Summary Report

This report has been prepared to assess the details provided to discharge conditions 14, 15, 16, 17, 20, 24, 28 for Bicester Eco Town Exemplar Site, Banbury Road, Bicester under Application Reference 21/01227/F.

The planning application constitutes a replan of the proposed Phase 4 of the development, comprising an amended house type mix and a change in the total number of dwellings within this phase from 54 to 57.

Figure 2 & 3. 3D Model (IES VE)

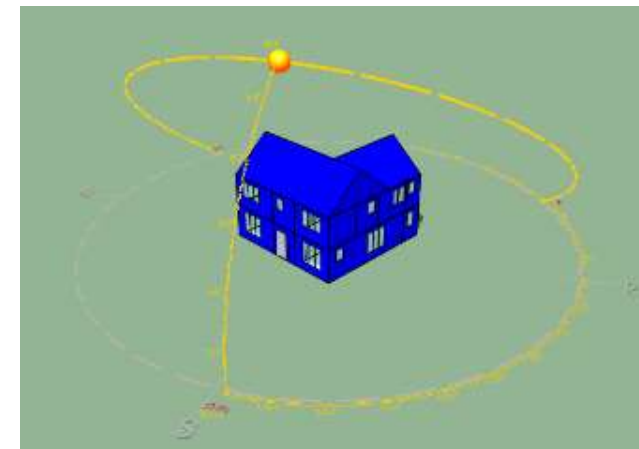
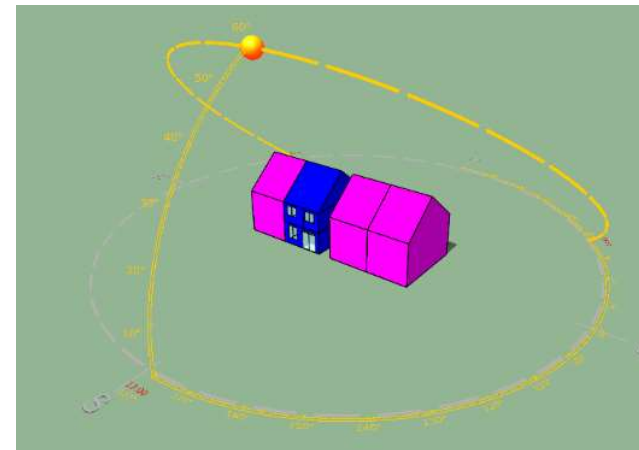
Section 6 of the Sustainability Statement introduced an overheating risk assessment for 2 buildings of different house types in accordance with CIBSE TM59 guidance. It is justified in the application that the modelled buildings have been selected as their orientation and glazing areas represent worst-case scenarios for the development.

The presented results show that the initial fabric configuration fails to comply with CIBSE TM59 requirements. The mitigation measure allowing the analysed buildings to comply with both CIBSE TM59 requirements is adopting a glazing g-value of 0.50 to all elevations instead of the initial specification (0.72).

Table 3 of the Overheating Assessment shows different construction specifications than in Table 2 of Section 3, namely different u-values for the external walls. Clarification is required on the construction specification considered in the overheating analyses.

Figure 5. Total kgCO₂e by resource type

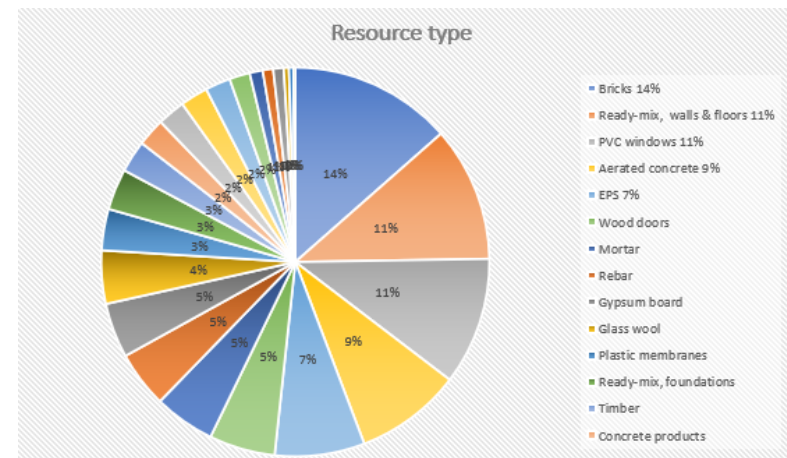
An embodied carbon assessment is provided in the Sustainability Statement for 1 house type. Further clarification is required on the choice of a single building.

The major resource contributors to the embodied carbon of the buildings are identified. Carbon footprint reduction options are presented for the most impactful materials. However, the measures provided are generic and it is not confirmed that any of the measures will actually be delivered.
